**Consultation Response from KC,
Highways Development Management**

2026/90290 land off, Reservoir Street, Dewsbury, WF13 4LF

Erection of 3 pairs of semi detached dwellings with on site parking

Date Responded: 28/05/2026

Proposed Site Plan

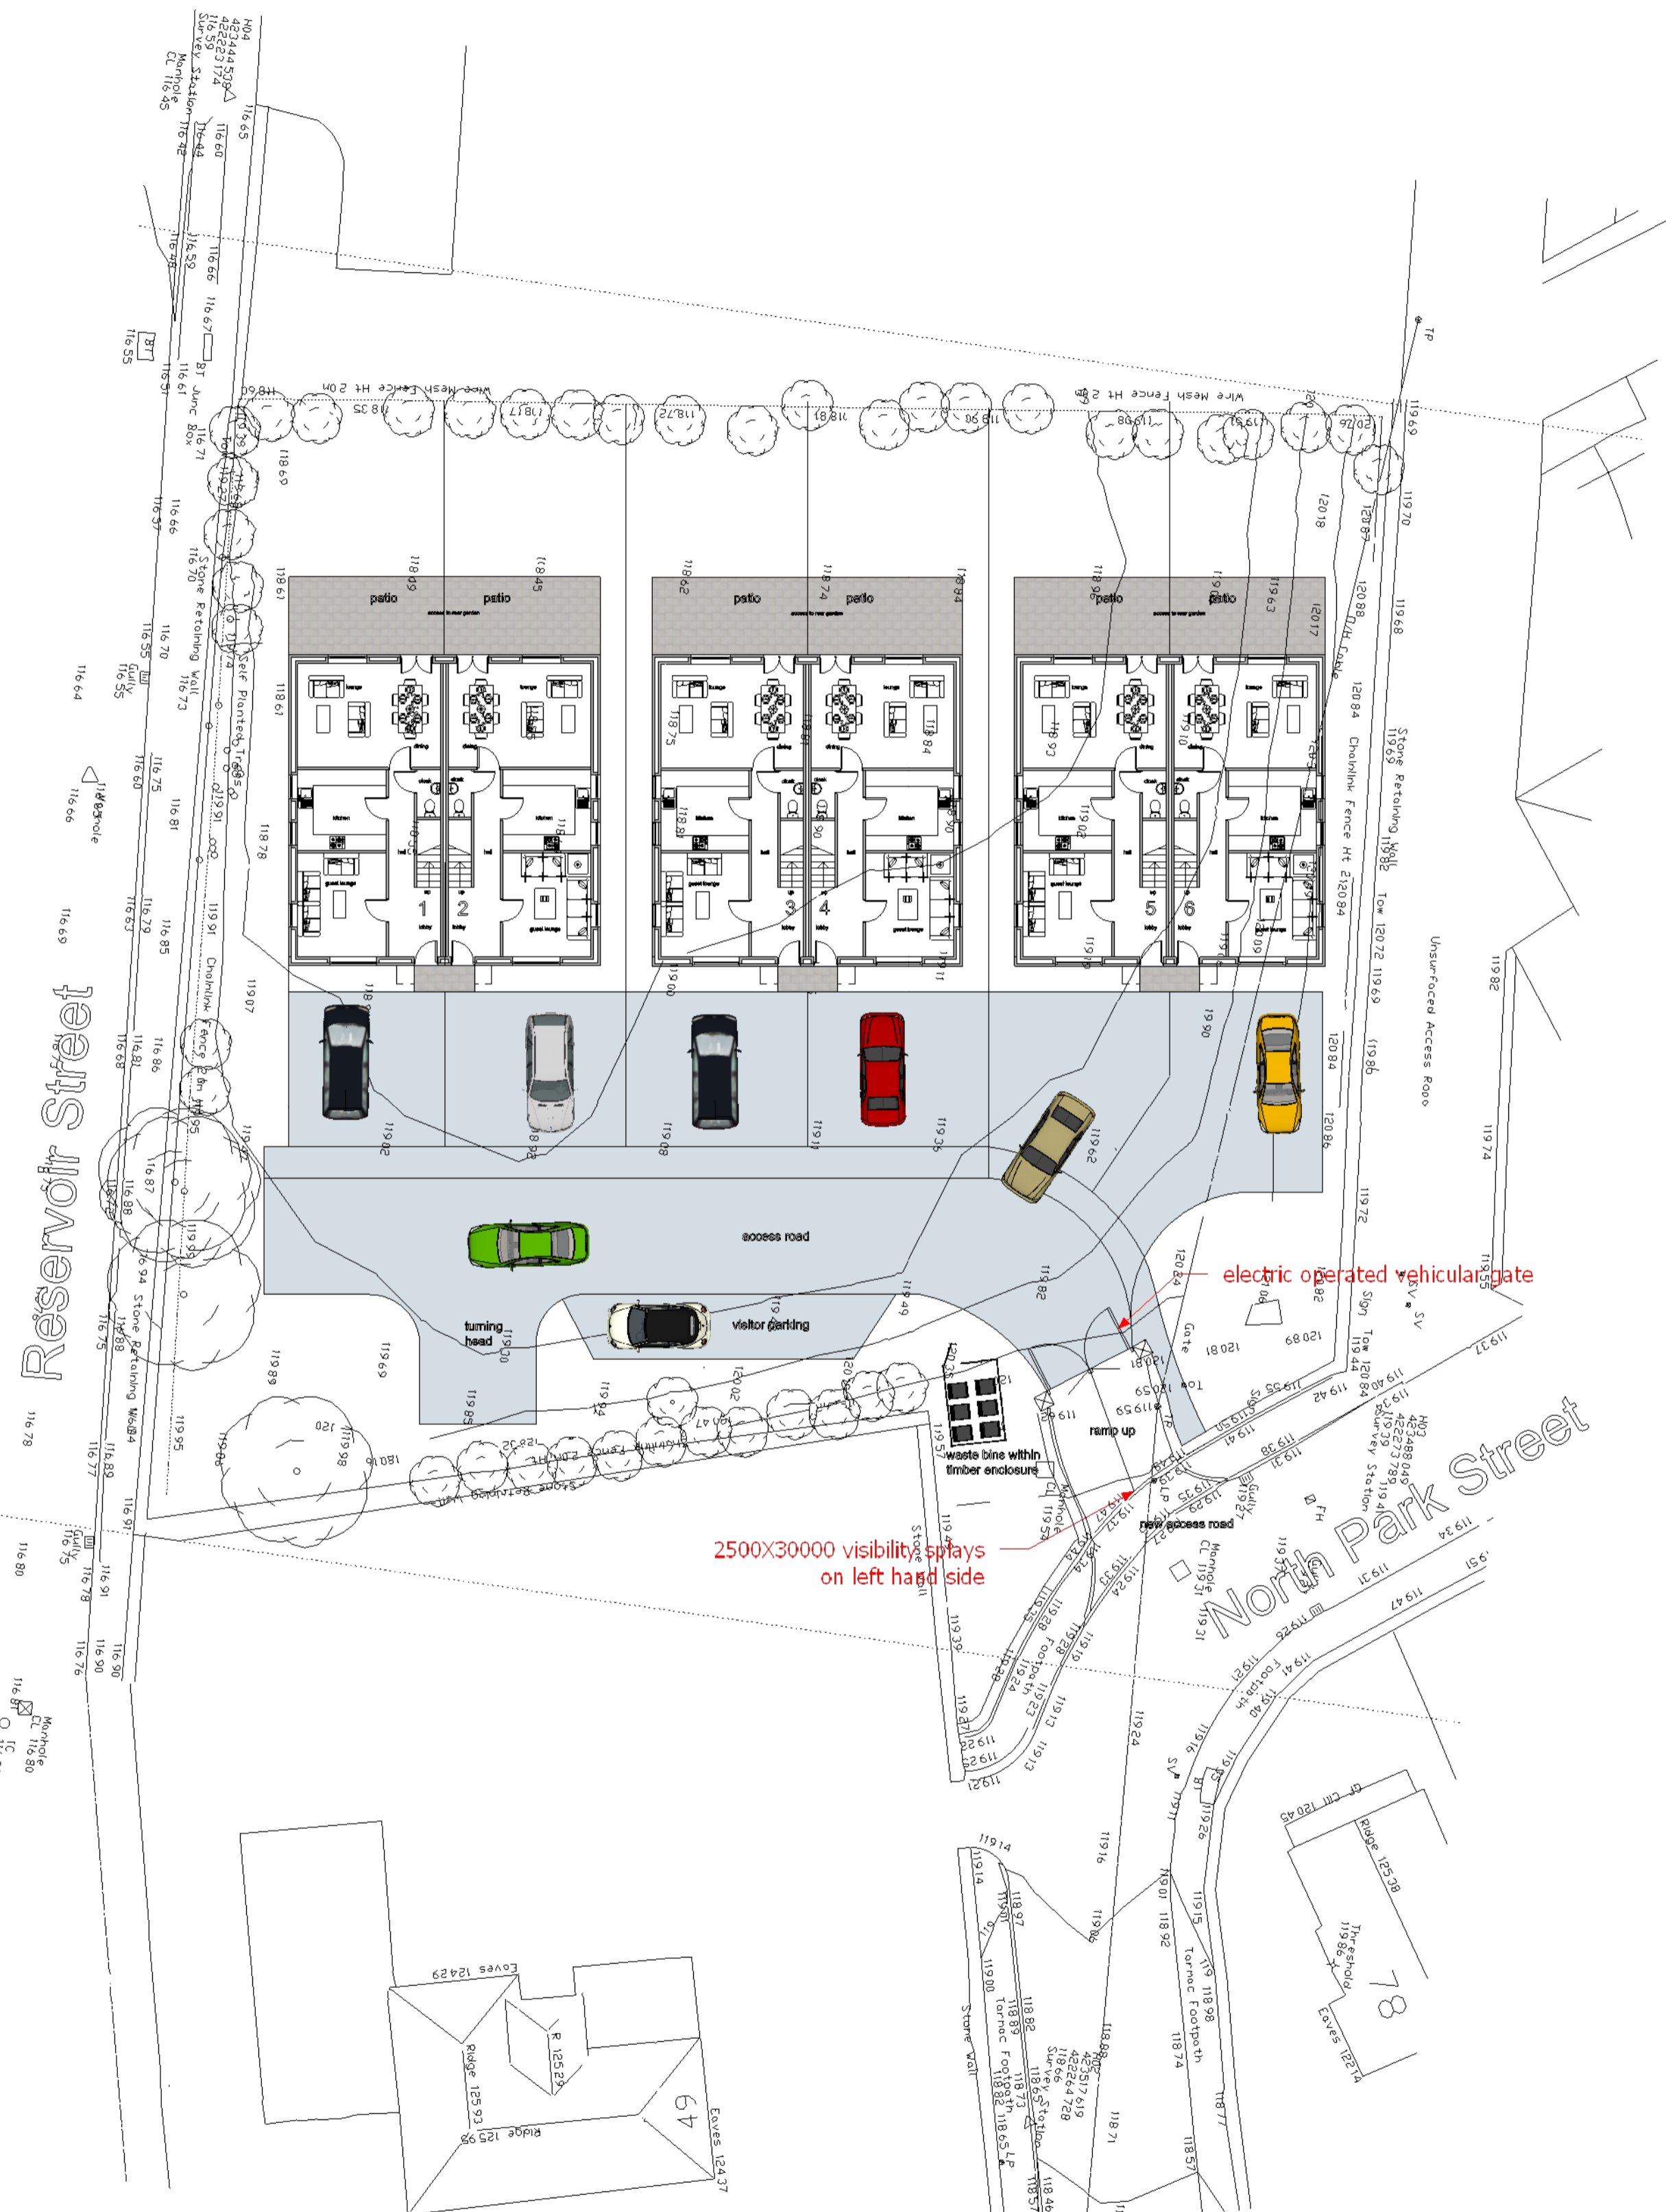
In this instance therefore, the proposal is for six dwellings and the access road into the site will need to be constructed to an adoptable standard and offered to the Highway Authority for adoption.

Parking for 2 cars per dwelling have been proposed, together with internal turning. This falls short of the recommended minimum parking requirements.

A minimum of 3 car parking spaces per 4 bedroomed dwelling should be provided.

Unfortunately, the size of the proposed site is too small to achieve this and could lead to vehicles parking on North Park Street in close proximity to the bend which would be detrimental to road safety at this location.

As such the proposal cannot be supported by Highways D.M as submitted and it may be better to reduce the number of houses which will allow for the recommended parking provision to be provided within the site.
